City of Portland, Maine - Building or Use Permit Application

Location of Construction: 1 Josslyn St	Owner Name: Portland Housing Authority	Owner Address: 14 Baxter Blvd	Phone: CITY OF PORTLAND
Business Name:	Contractor Name: M & M Industries	Contractor Address:	Phone:
Lessee/Buyer's Name:	Phone:	Permit Type: Alterations - Commercial	Zone: E-5

Proposed Project Description: Add a farmer's porch to the community bldg.	FIRE DEPT: <input checked="" type="checkbox"/> Approved <input type="checkbox"/> Denied	INSPECTION: Use Group: <i>Mixed</i> Type: <i>SB</i> <i>IBC 2003</i>
	Signature: <i>[Signature]</i>	Signature: <i>[Signature]</i>

Add a farmer's porch to the community bldg.

PORTLAND HOUSING AUTHORITY  
SAGAMORE VILLAGE  
COMMUNITY BUILDING  
**A.2**

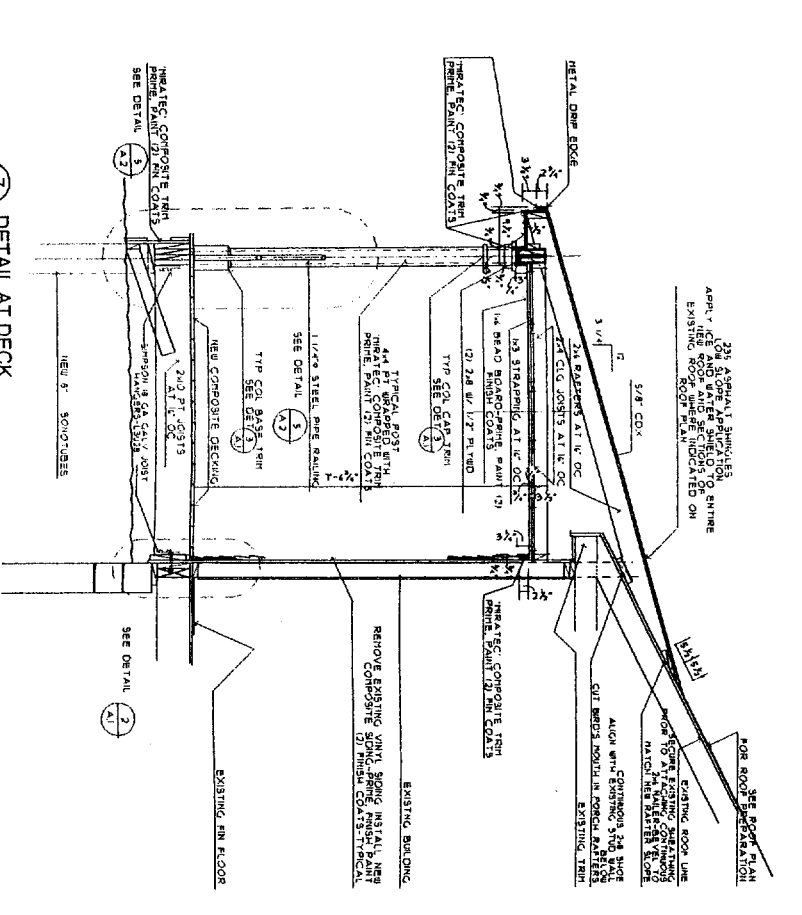
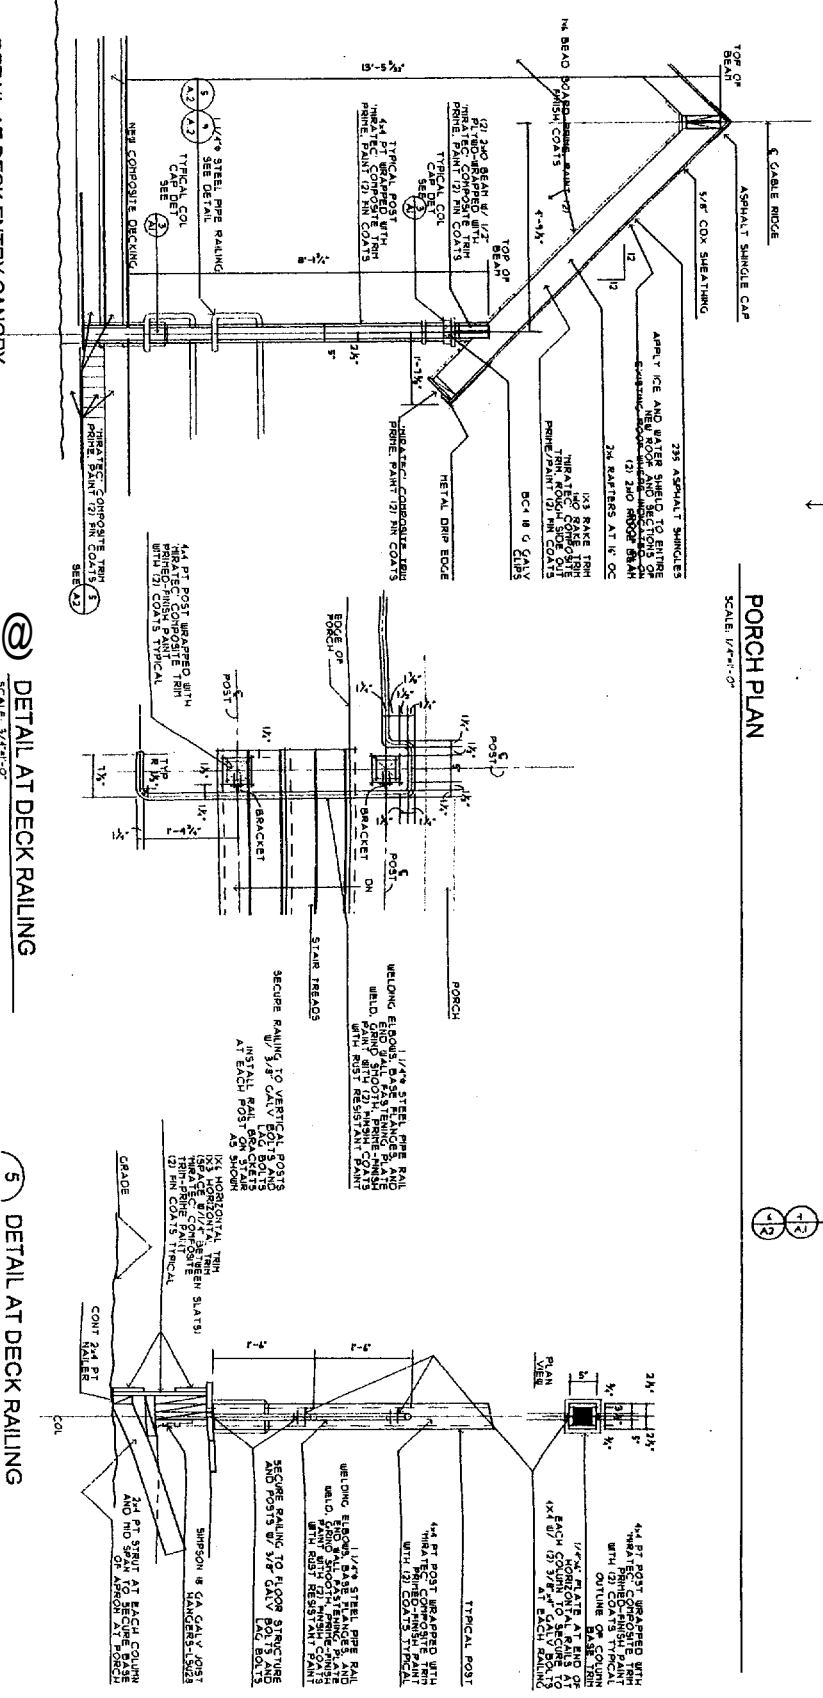
1) guard rail shall be provided if over the porch is more than 30" above grade

2) stairs shall have no nosing
